**WELWYN HATFIELD BOROUGH COUNCIL
ASSISTANT DIRECTOR (PLANNING)**

Application No: 6/2024/0071/HOUSE
Location: 38 Barleycroft Road Welwyn Garden City AL8 6JU
Proposal: Erection of a part single, part double storey rear extension to replace existing rear extension, single storey side extension and conversion of existing outbuilding, raising of roof to existing garage, installation of a rear dormer window to facilitate a loft conversion. Insertion of first floor side window, installation of rooflights in existing roof
Officer: Ms Louise Sahlke

Recommendation: Refused

2 38 Barleycroft Road
Block plan 1:500

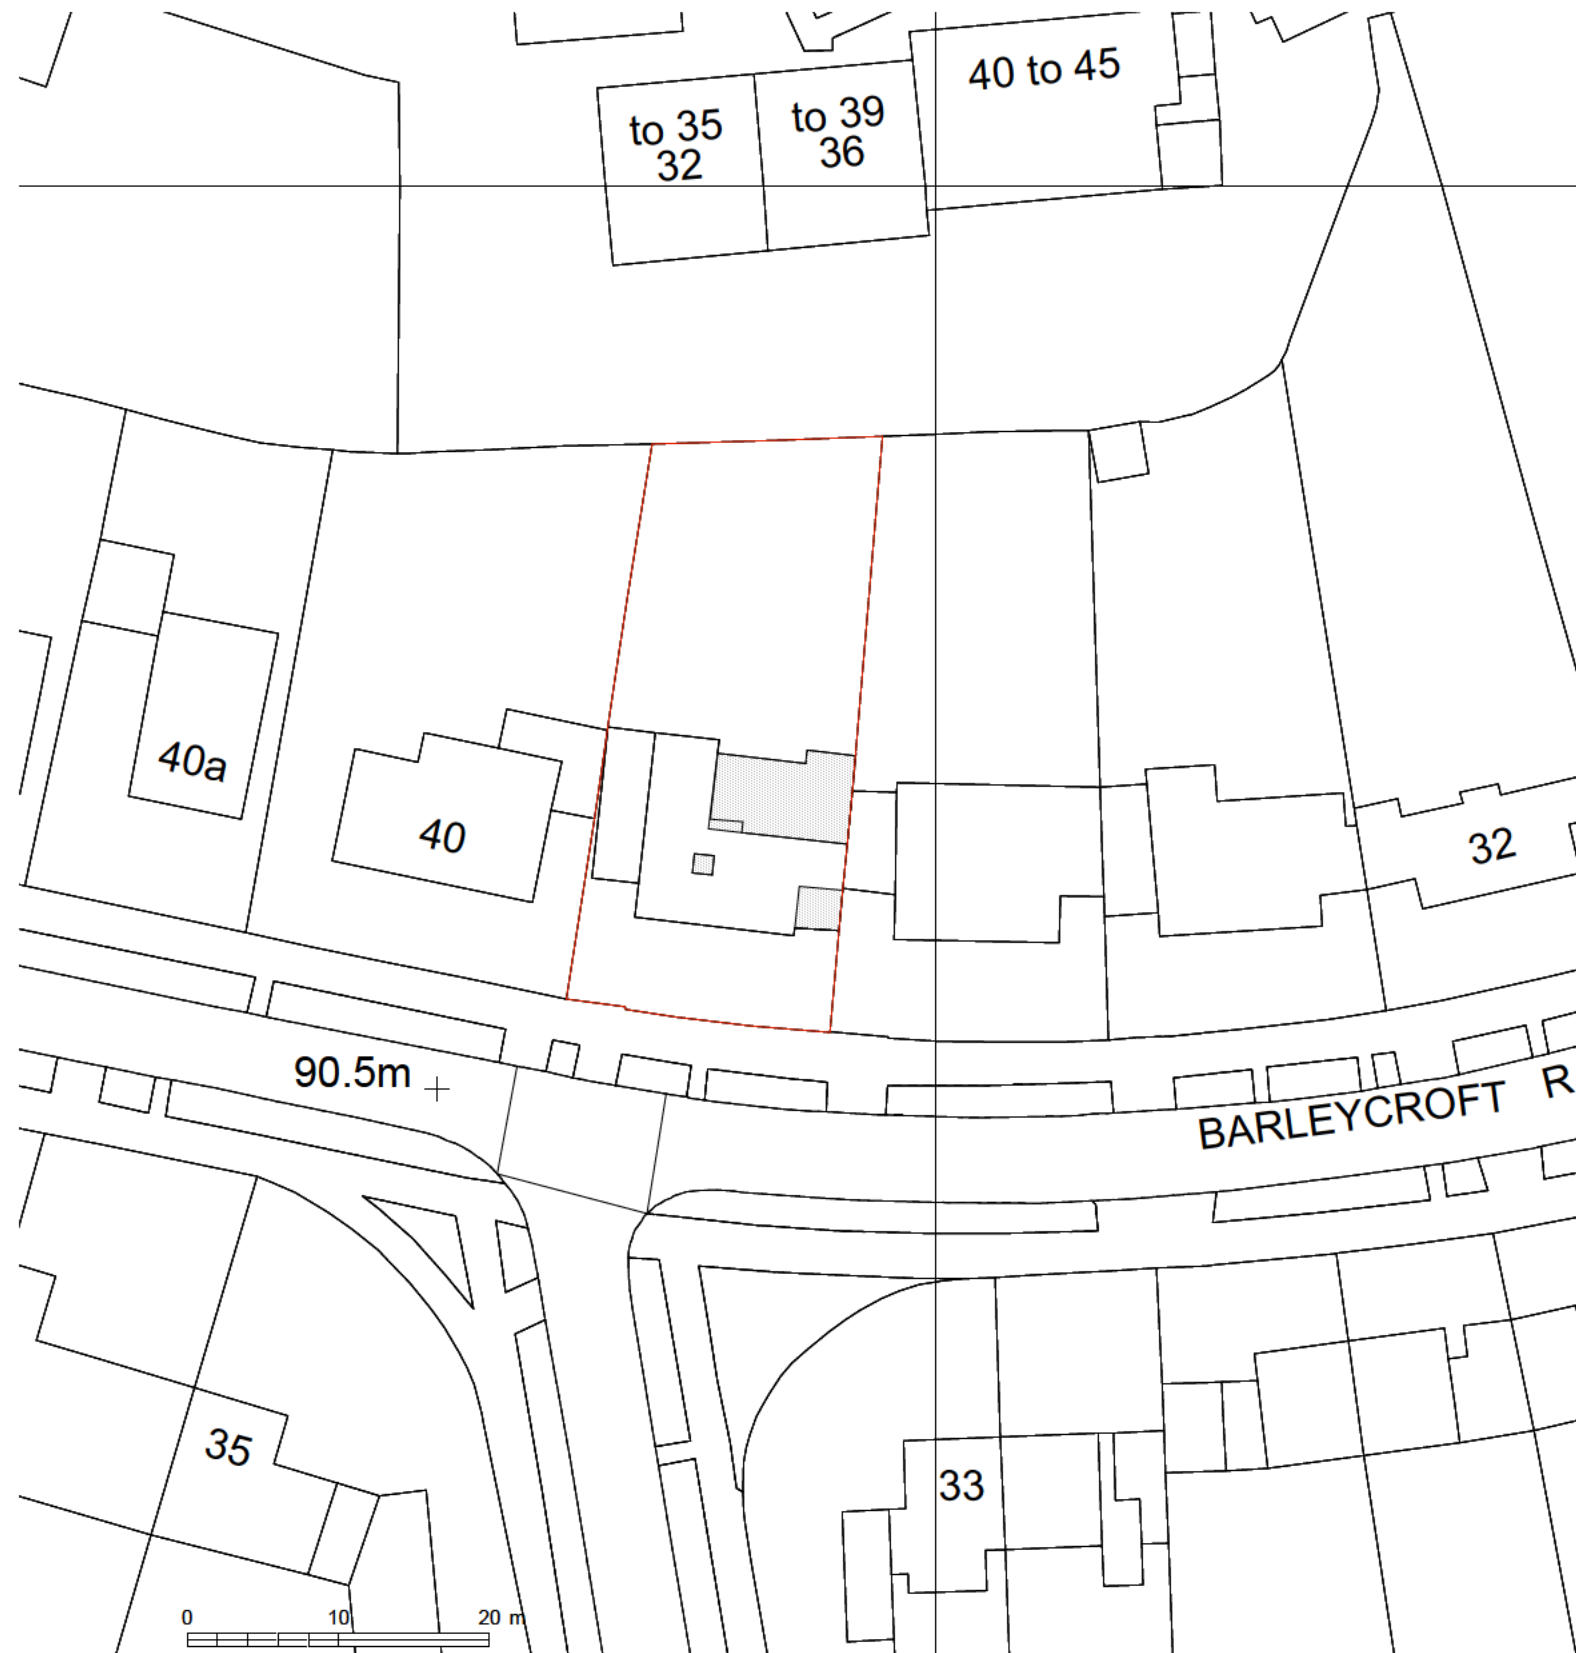
<p>Under the Estate Management Scheme, (6/2022/2512/EM), consent was given for the creation of an additional off street car parking space.</p> <p>The proposed block plan does not indicate 3 parking spaces which meet the size standards of 2.4m x 4.8m. Despite this, there would be adequate space for at least two cars on the site frontage and within the existing garage. There are also bus stops and cycle routes nearby providing connections by alternative modes of travel to the private car. It is therefore considered that this would not, in itself, provide a separate reason for refusal.</p>
Any other considerations	Concerns have been raised in regard to the impact of the proposed side extension on the neighbouring party wall. This is not a material planning consideration as it falls under separate legislation.
Conclusion	
<p>Having regard to the above, it is concluded that the proposal would not preserve or enhance the character and appearance of the Conservation Area, in conflict with the requirements of S72 of the planning (Listed Buildings and Conservation Areas) Act 1990. Paragraph 205 of the NPPF requires that great weight should be given to the conservation of a heritage asset.</p> <p>The development would result in less than substantial harm to the Conservation Area. Consequently, Paragraph 208 of the NPPF requires this harm to be weighed against the public benefits of the proposal. No public benefit is identified that would overcome the identified harm.</p> <p>Accordingly, when considering the effect on the Conservation Area with no public benefits, the development would be contrary to the development plan and there are no material considerations which outweigh the identified harm.</p>

2 38 Barleycroft Road
Roof plan 1:100

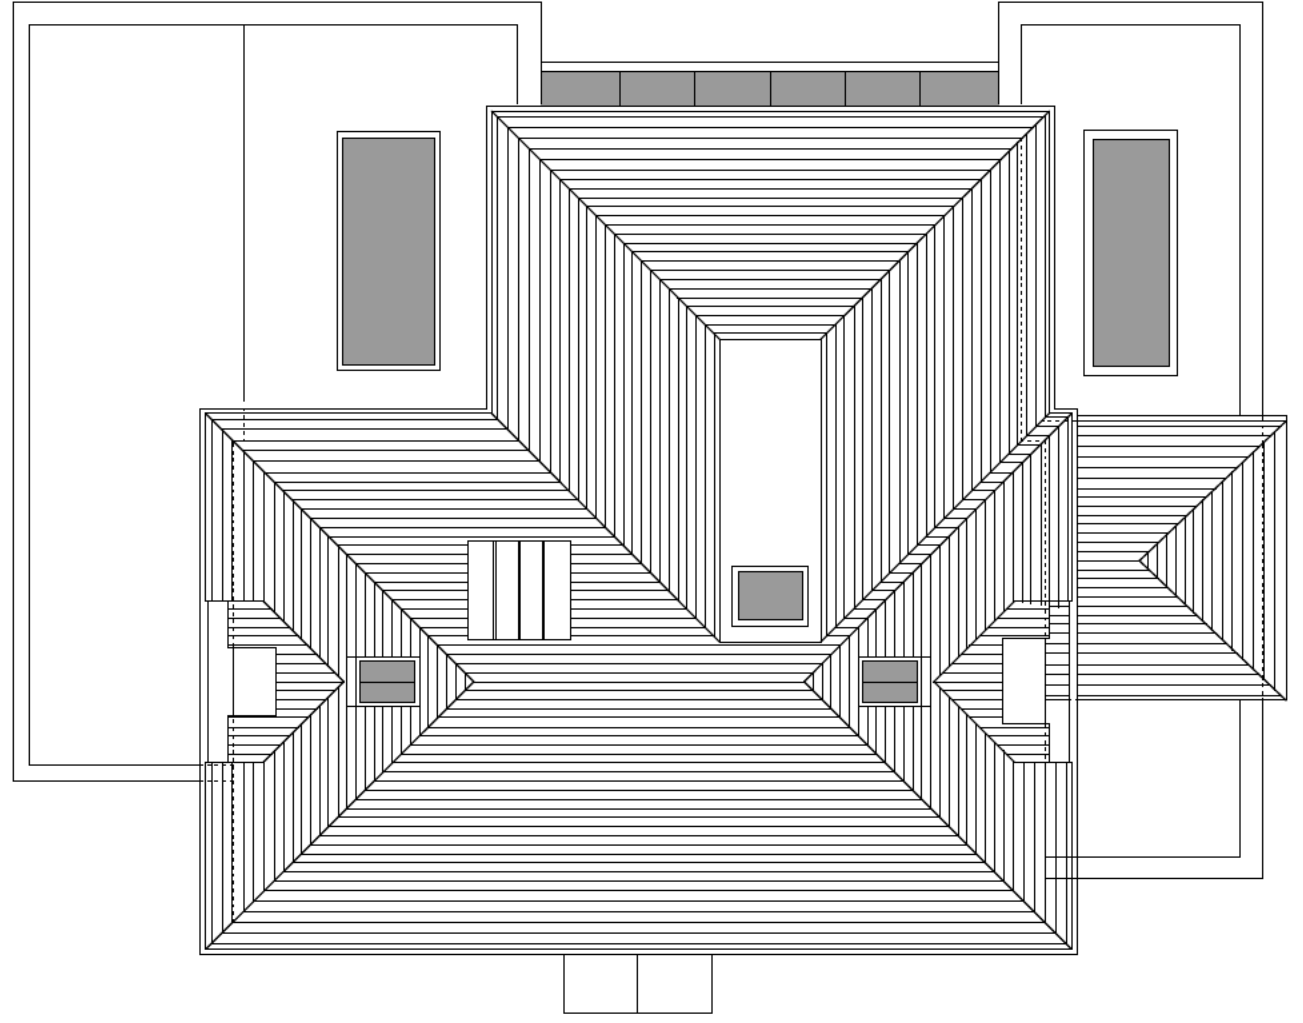
Whilst in isolation some elements of the proposed development would be acceptable, the combination of the rear extensions, by virtue of their cumulative width, depth and height, and the overall design, would fail to be subordinate in scale or appearance to the original dwelling. The crown roof would also be out of character with the simple hipped roof of the existing dwelling.

In respect of the crown roof detail, there are a limited number of applications which have been approved on Barleycroft Road with crown roofs, including at No.21 and No.40. It is important to note that a local planning authority is not bound by an earlier decision to approve an application, but it is required to have regard to the importance of consistency in decision-making. It is not therefore unreasonable to take a different view to a previous application, provided there is justification to explain why the LPA has reached a different decision.

1 38 Barleycroft Road  
Ground floor plan 1:100

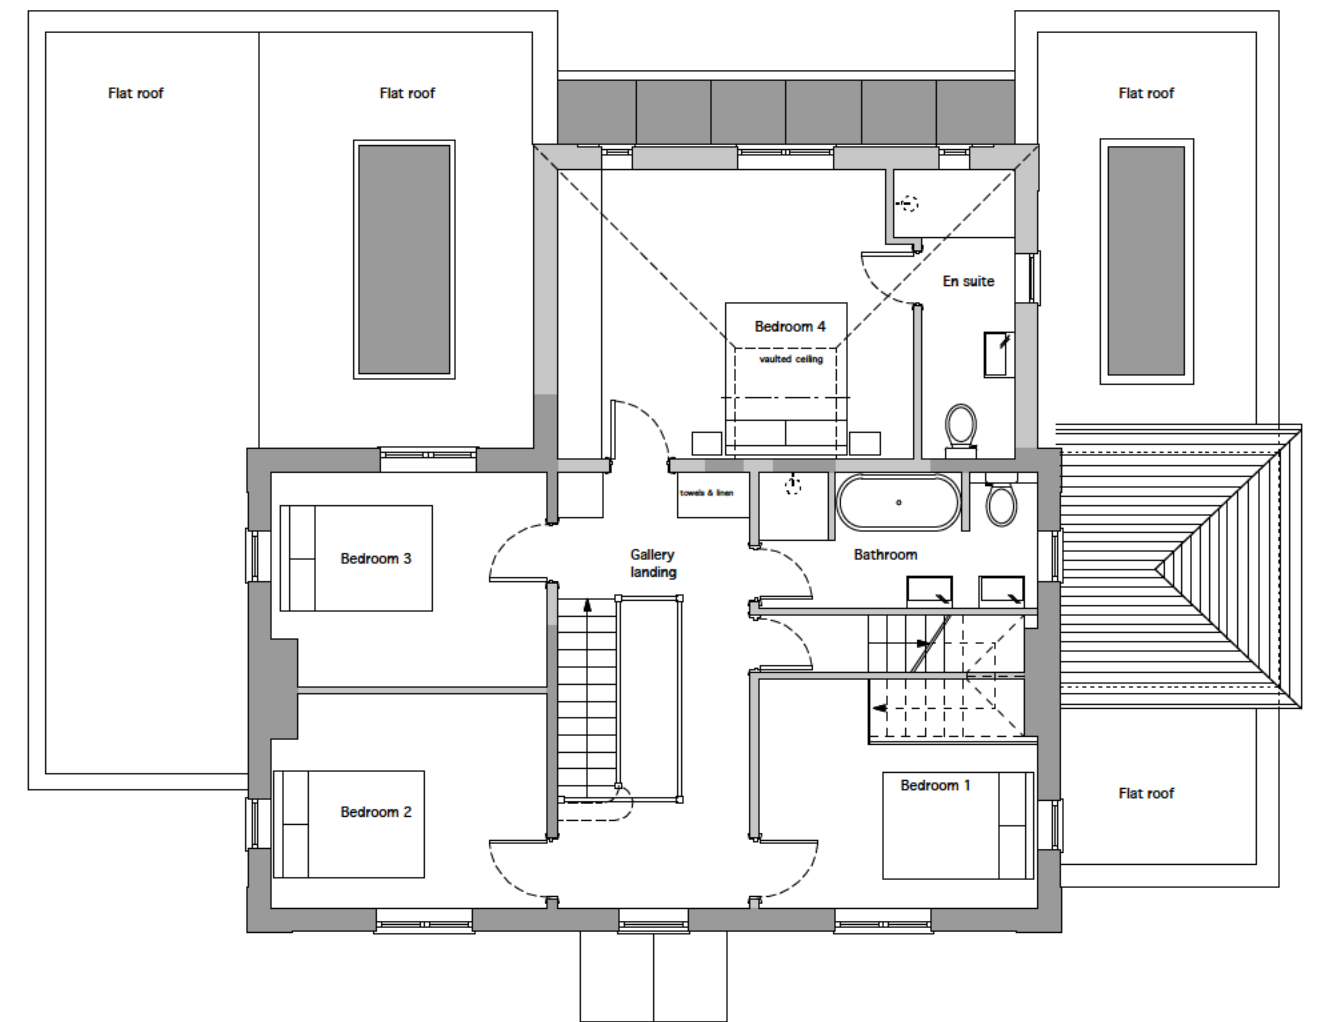
The proposed rear extension is large in size as discussed above and due to the width of the first floor rear extension it has to incorporate a crown roof.

The proposed part two, part single storey rear extension would project behind the existing rear building line of 36 Barleycroft Road. The nearest element is single storey in height and would extend approximately 2.5metres behind the existing rear building line of 36 Barleycroft Road. This element at the nearest point to the boundary is 3.3 metres in height and wraps along the flank elevation of 36 Barleycroft Road.

The two storey element would be located approximately 3.3 metres in from the boundary line with 36 Barleycroft Road. Therefore it is not considered that the bulk, size, height and massing of the rear extension or side extension would result in significant overdominance, or a loss of daylight/sunlight or outlook to 36 Barleycroft Road's dwelling or gardens.

1. The proposed part two, part single storey rear extension, by virtue of its siting, height, mass, scale and detailed design, fails to relate well to the character and proportions of the existing building, the surrounding context or the street scene. The proposed development would therefore fail to respect the character of the dwelling or preserve or enhance the character and appearance of the Welwyn Garden City Conservation Area and would be contrary to Policies SP9, SP15 and SADM15 of the Welwyn Hatfield Borough Council Local Plan, Section 72 of the Planning (Listed Buildings and Conservation Areas) Act 1990, the Welwyn Hatfield Supplementary Design Guidance 2005, and the National Planning Policy Framework.
